We do not recommend discharge of conditions at this time. Following our previous correspondence one of our engineers has now visited the site and observed the in-situ drainage. Our inspection has confirmed the following:

Scale	NTS	Date	06.08.21
Drawing No	E24121_12	Rev	-

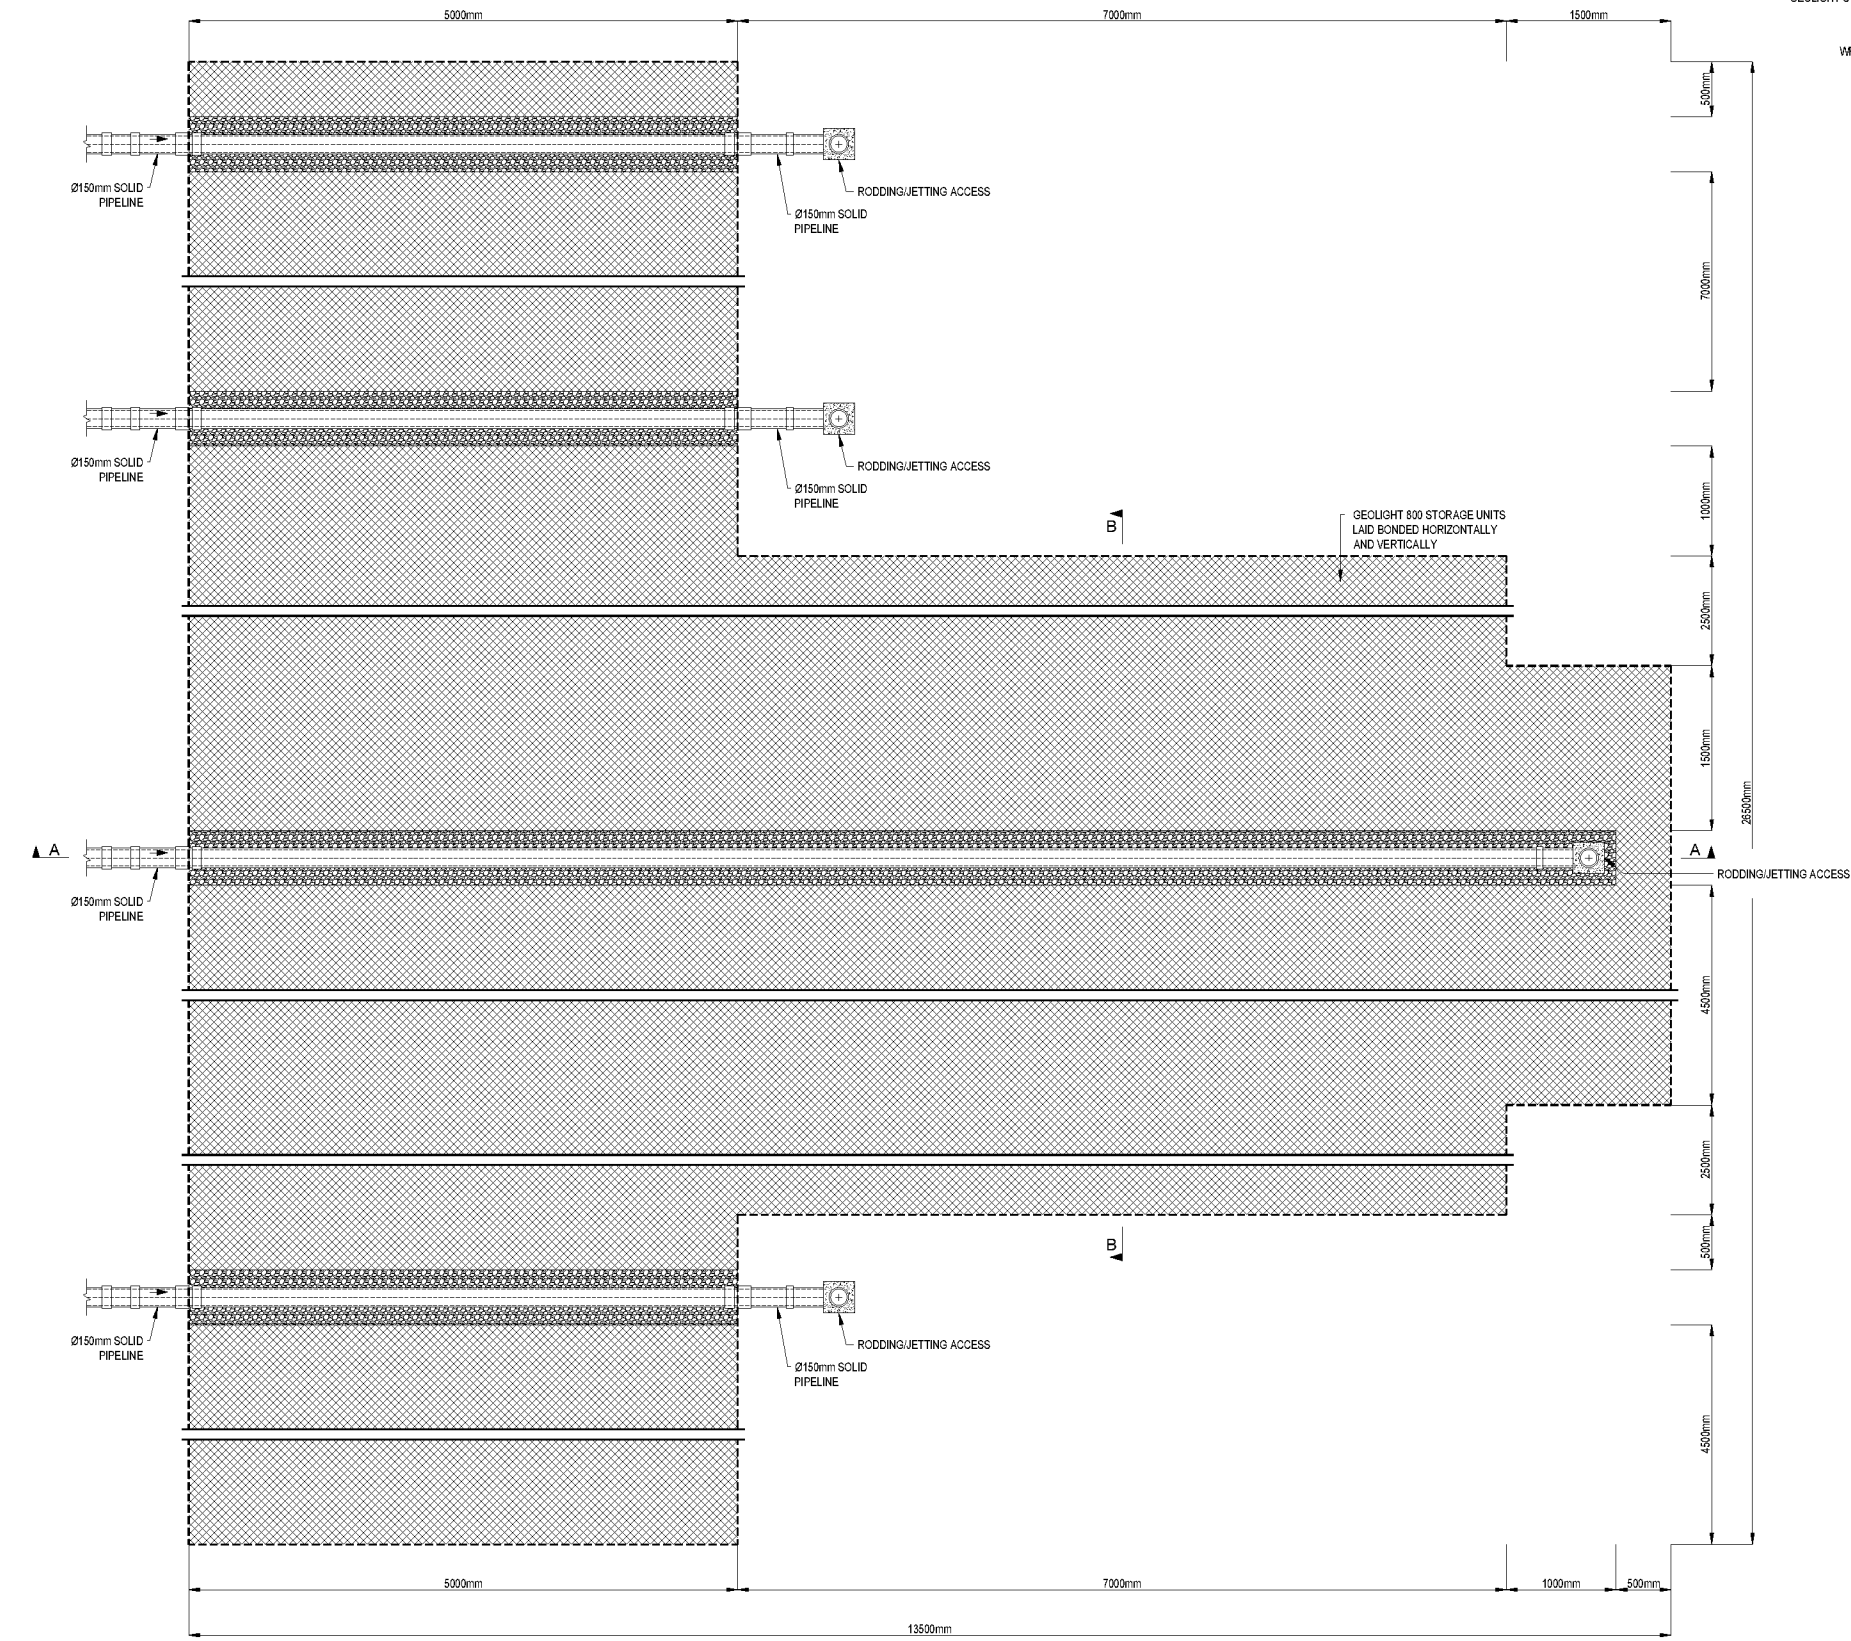
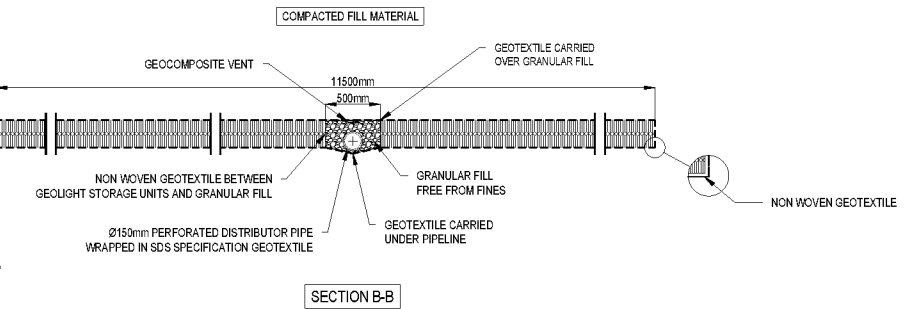
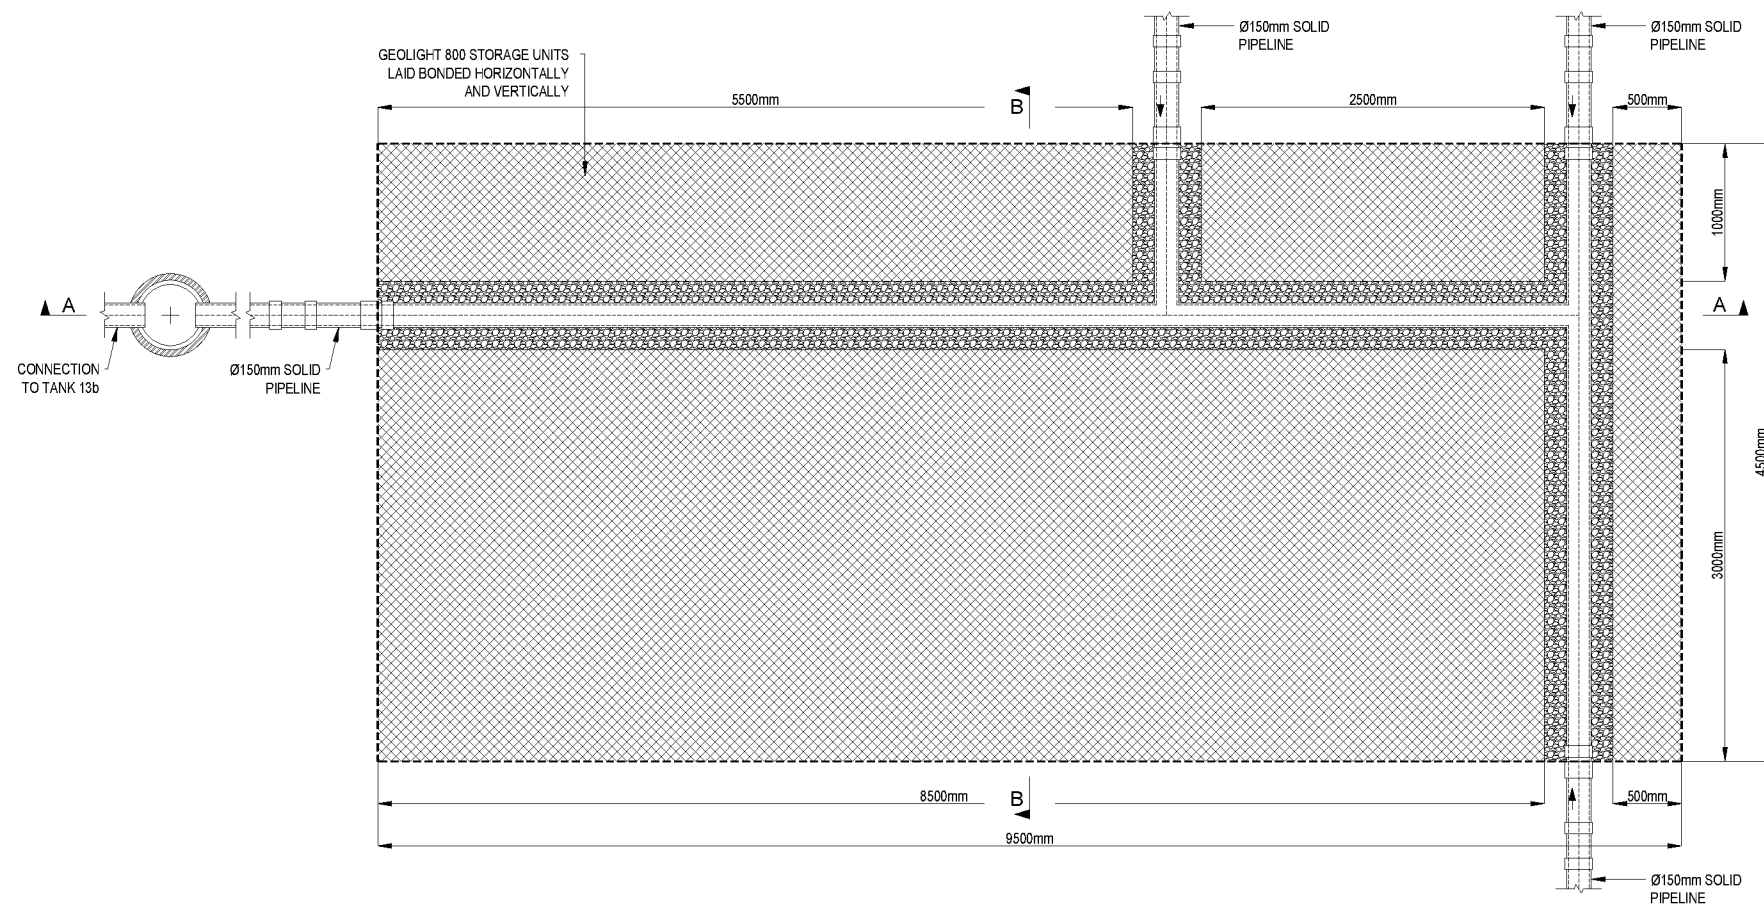
2. Manhole S72 (inlet to infiltration tank west of plot 33);
 - a) This manhole is specified as silt trap with 300mm sump. The silt trap that has been constructed is of an unconventional design and does not appear to be 300mm deep as originally designed. This silt trap will need remediation.

- b) The twin incoming pipes to MH S72 have been constructed as 150mm diameter pipes, as opposed to 225mm diameter. This will impact the capacity of the surface water drainage system to convey runoff. As Odyssey has not remodelled the pipework, it is possible this change could result in flooding of properties unless remediated or remodelled to confirm it does not cause flooding.

- c) The outlet from MH S72 is a single 150mm diameter pipe, Drawing Yap-130-082 shows this should have been two no. 225mm diameter outlets, connecting into the inspection channels (which are also not present). As Odyssey has not remodelled the pipework it is possible this change could result in flooding of properties unless remediated or remodelled to confirm it does not. We also have concerns about the impact this may have on siltation, and air locking of the soakaway during high flows, as there is no vent system in place.

- d) The outlet to MH S74 does not exist and hence MH S74 does not exist either.
3. Infiltration tank west of Plot 33;
 - a) The proposed access manholes to provide a means of inspection into the crates do not appear to exist. Inspection manholes must be constructed, and an inspection of the crates carried out to verify they have been built as designed.

Scale	NTS	Date	06.08.21
Drawing No	E24121 14a	Rev

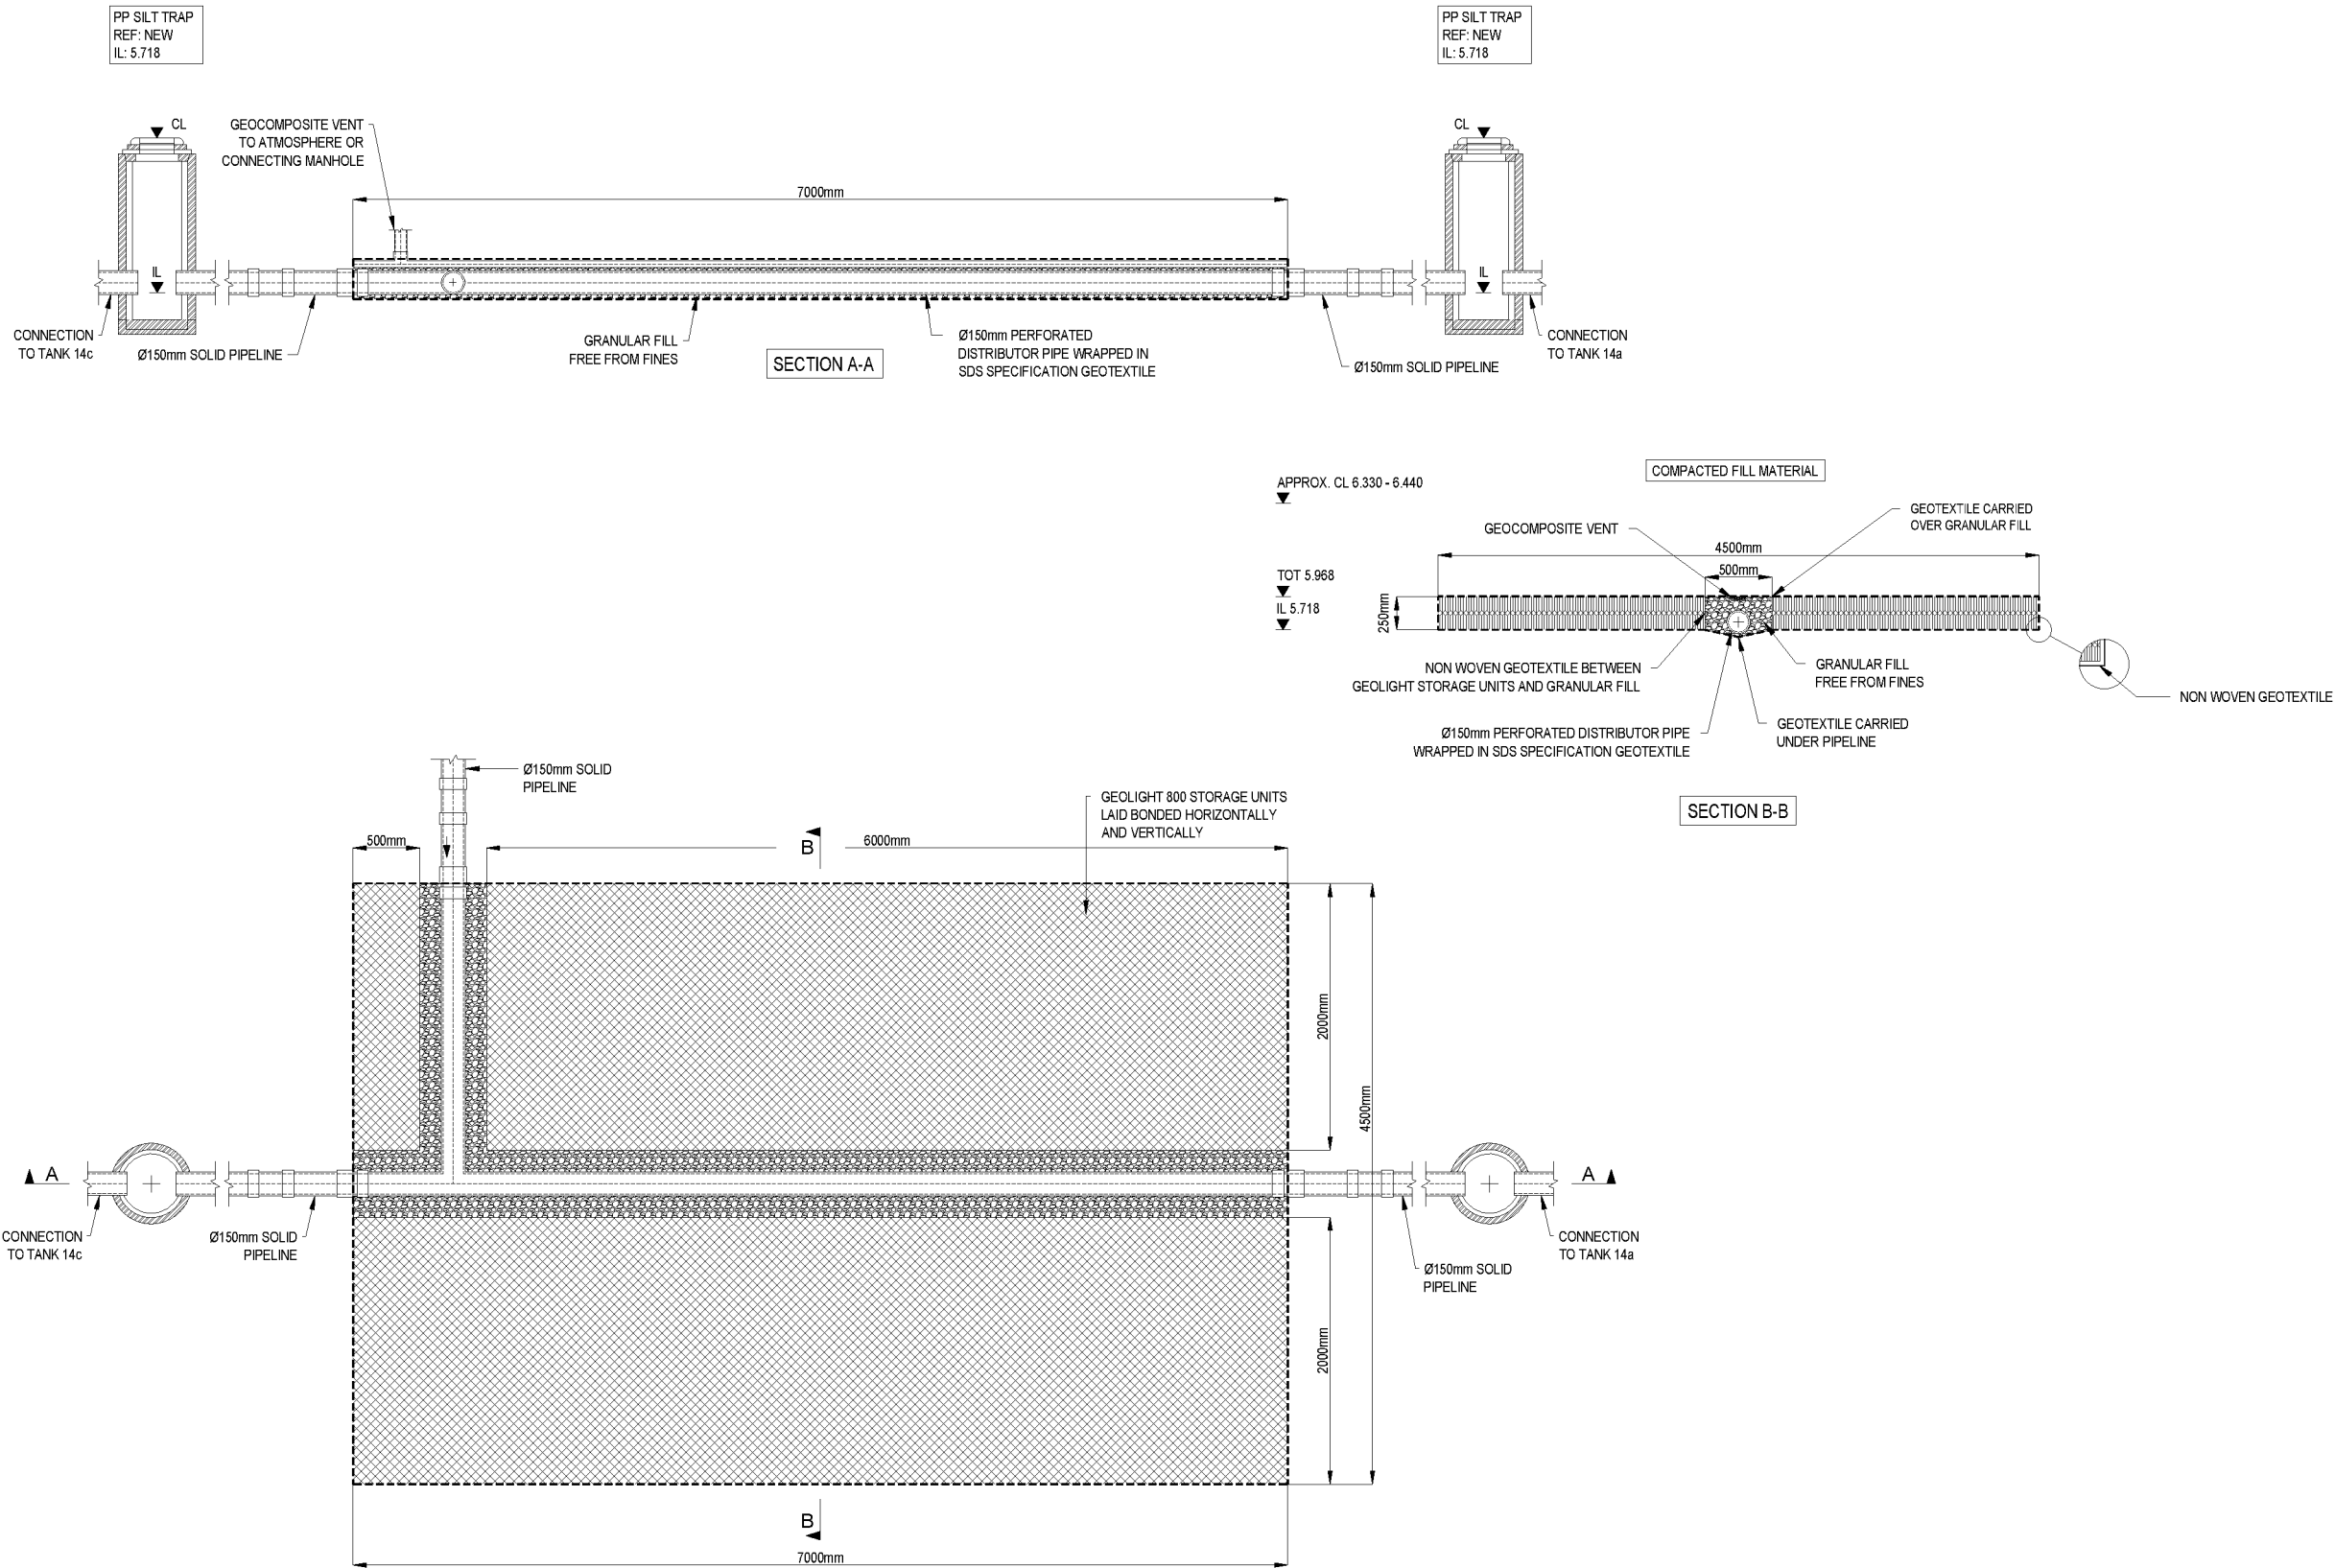
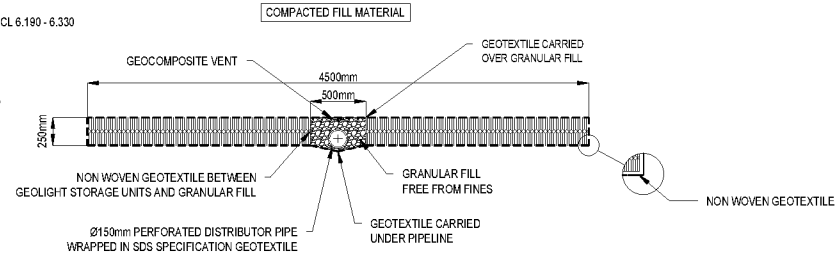
- b) This manhole is a poor quality installation, mortar droppings need cleaning out and the surface made good.
8. The installed permeable paving system uses a product called GEOLight (as denoted in Odyssey's verification report). Photographs of the installation of the permeable paving system do not match the design drawings for GEOLight, available on SDS's website. We have subsequently spoken to SDS, who has confirmed that the installation does not appear to follow one of their approved designs.

- The attenuation matts should be wrapped with a geo-textile (lined) to prevent gravel migrating into the honeycomb structure. This is designed to separate the gravel from the attenuation matts. This is applicable for infiltration as well as tanked systems. The photograph shows the liner in the incorrect position.

- The system is generally laid in a checkerboard pattern to prevent the flow of water through the sub-base becoming blocked in one direction. The photograph shows the system laid in one direction.

- The photograph also shows what appears to be a discolouration, indicating mud or other site backfill has been used around one of the manholes. If this is the case and some of the material used did not comprise washed gravels, this would permit fine material to clog the system, potentially impacting its functionality.
